**From:** Contact Centre (CRM) <contact@ribblevalley.gov.uk>  
**Sent:** 10 August 2024 20:59  
**To:** Planning  
**Subject:** Planning Application Comments - 3/2024/0614 FS-Case-637711317

**Planning Application Reference No.:** 3/2024/0614

**Address of Development:** 26 Whalley road BB6 8EJ

SITE PLAN

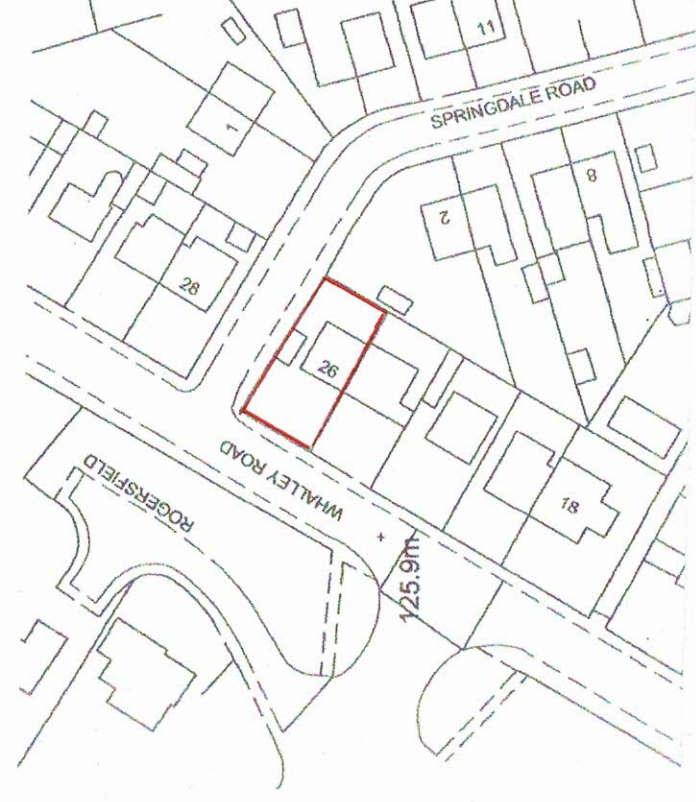
Side fence, reduction in height to 1m. If this property is still being proposed as a children's respite home I feel the reduction in height of the boundary fencing to a height which can easily be vaulted straight onto an admittedly quiet road would present an increased risk to the children, should one's behaviour become difficult. I am also worried concerning the open and close access to the main road for the same reason

Increase in car parking. With increasing rainwater run off problems, the council might consider stipulating a porous surface for the area presently garden

**Comments:** Concern regarding proposed alterations to the existing vehicular access and parking provisions are not linked to the previous planning application. These changes were proposed on a previous application 3/2024/0155 for change of use from C3 to C2 residential institution which was rejected.

PROPOSED PLANS AND ELEVATIONS

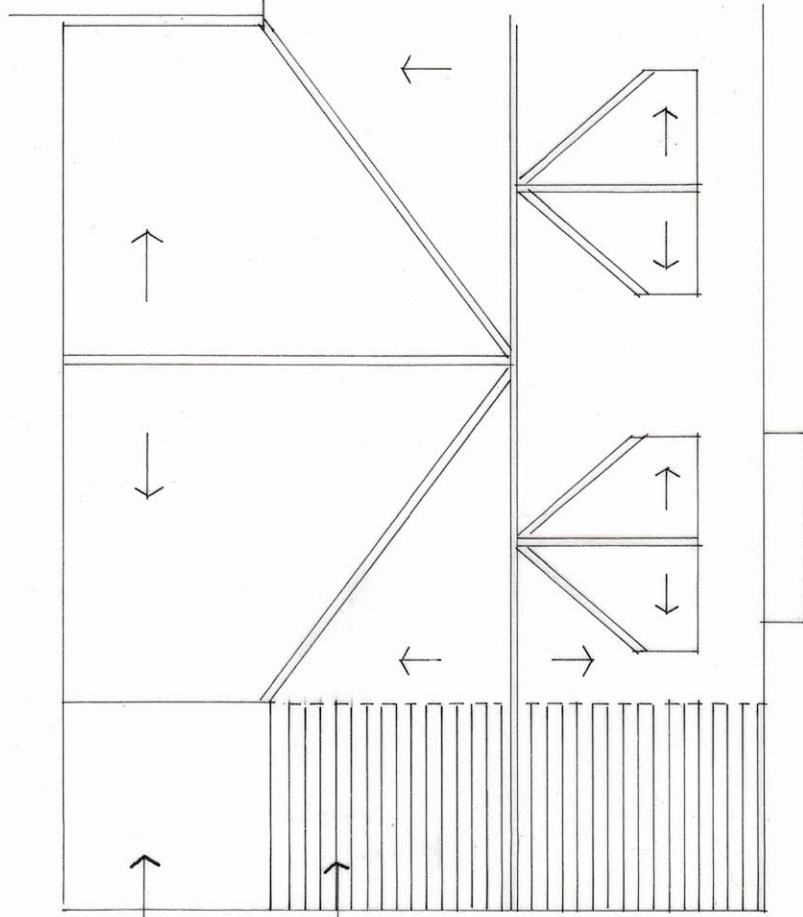
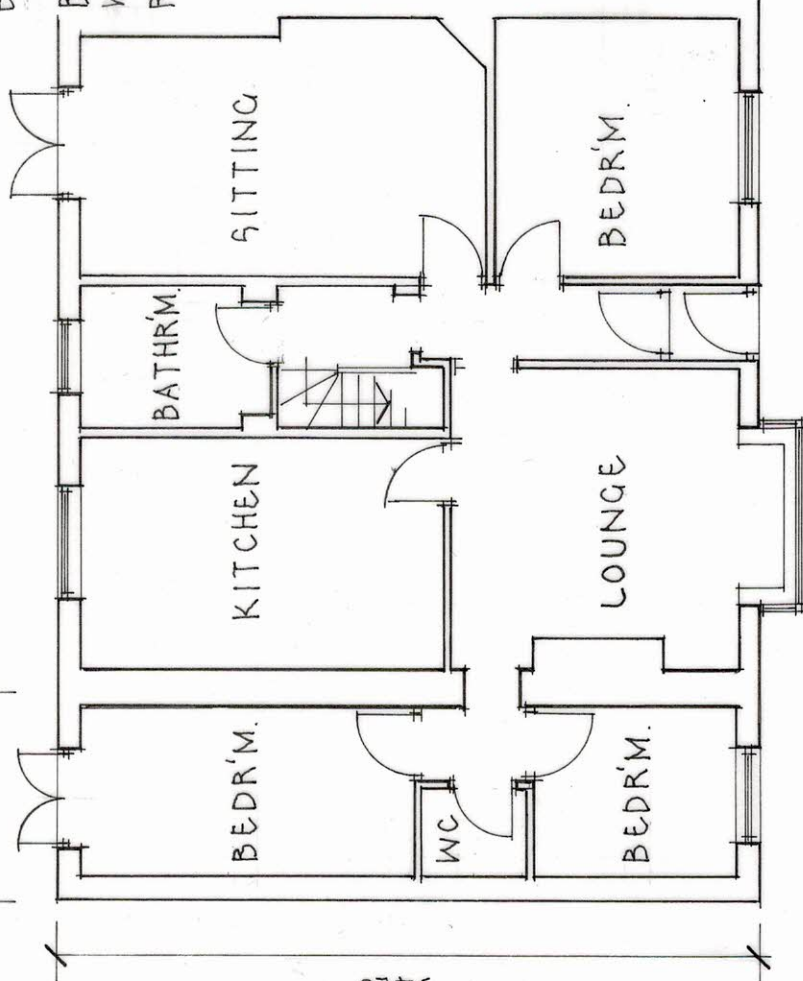
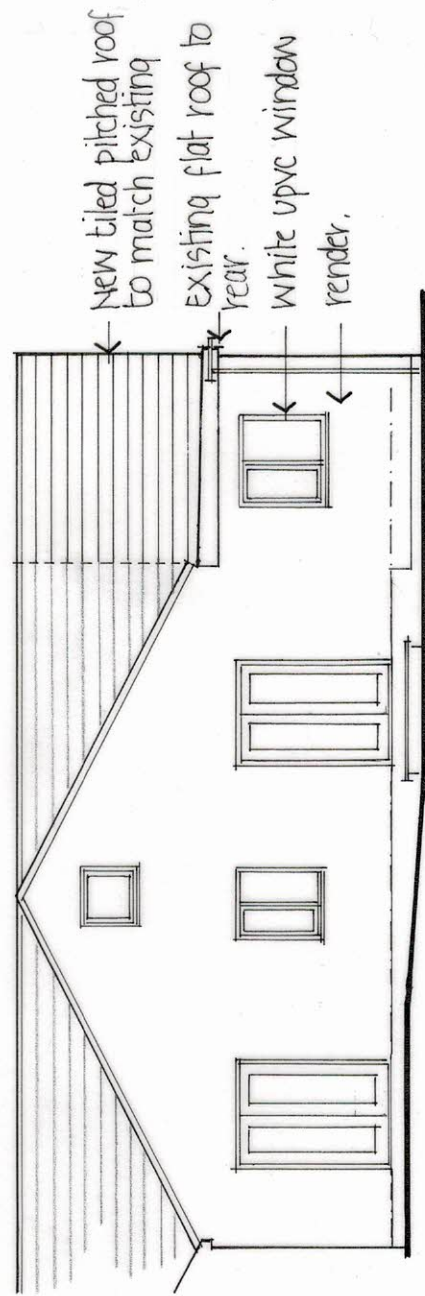
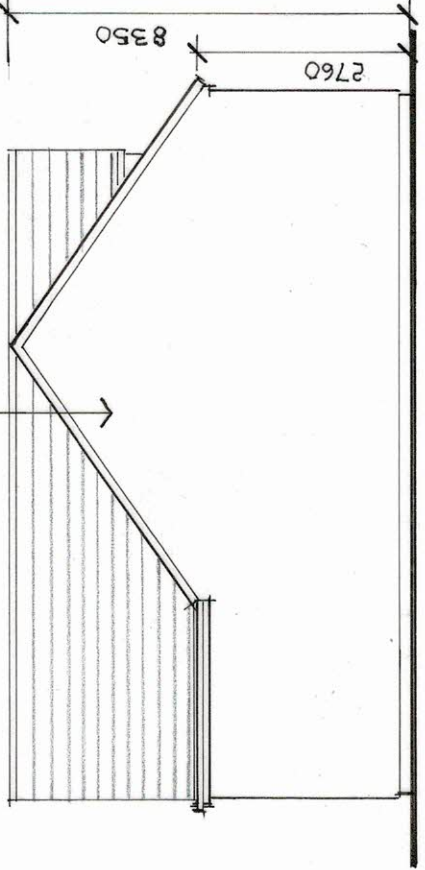
The Extension [REDACTED] in the statement says that planning permission was previously granted in 2012. What he doesn't say is that that permission was for a garage not two bedrooms and a wc. The pitched roof was slightly set back from the frontage and had no flat area on the back. The present extension built without permission in no way conforms with the previous permission granted, or will do if a pitched roof is fitted.
